Arts and Social Sciences Building, University of Wollongong (SSD 8596)

I am writing in response to the Department of Planning and Environment (DPE) letter dated 13 November 2017 inviting comment from the Environment Protection Authority (EPA) on the above development application.

Attachment A

Figure 4: University of Wollongong Site Map (existing)

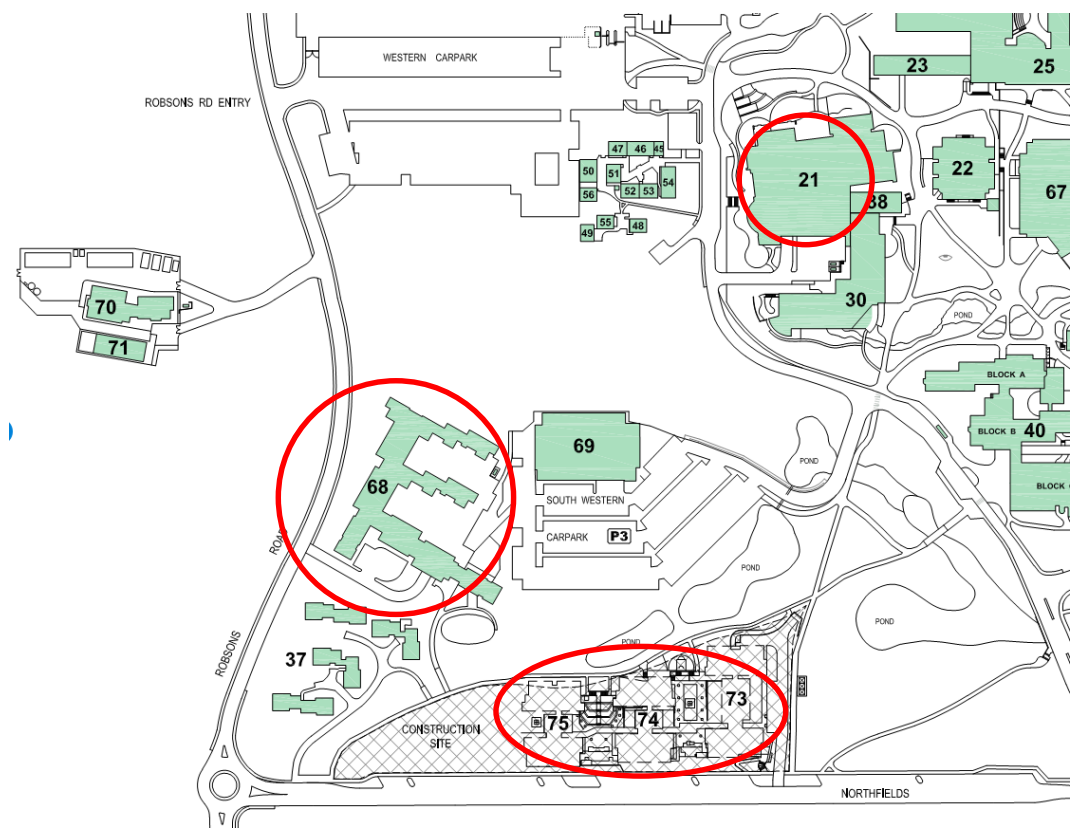
- a) The noise assessment states that the nearest noise-sensitive receivers for the project are the Kooloobong Village (student accommodation) and the University of Wollongong Early Start Facility. These receivers are located within the university premises. Based on the spatial services provided SIX Maps (NSW Department of Finance and Services) the residences along Dallas Street to the north of the carpark appear to be closer than the Kooloobong Village. Based on the acoustic assessment provided, the impacts on the nearest residential receivers to the north have not been assessed.

- e) For both the Early Start Facility and the Kooloobong Village, the predicted external construction noise levels provided in Table 11 of the Noise Assessment Report are significantly above the noise affected and highly noise affected management levels identified by the ICNG (Table 2). The predicted internal construction noise levels are also significantly above the management level identified by the ICNG (Table 3). No assessment against the management levels has been provided.
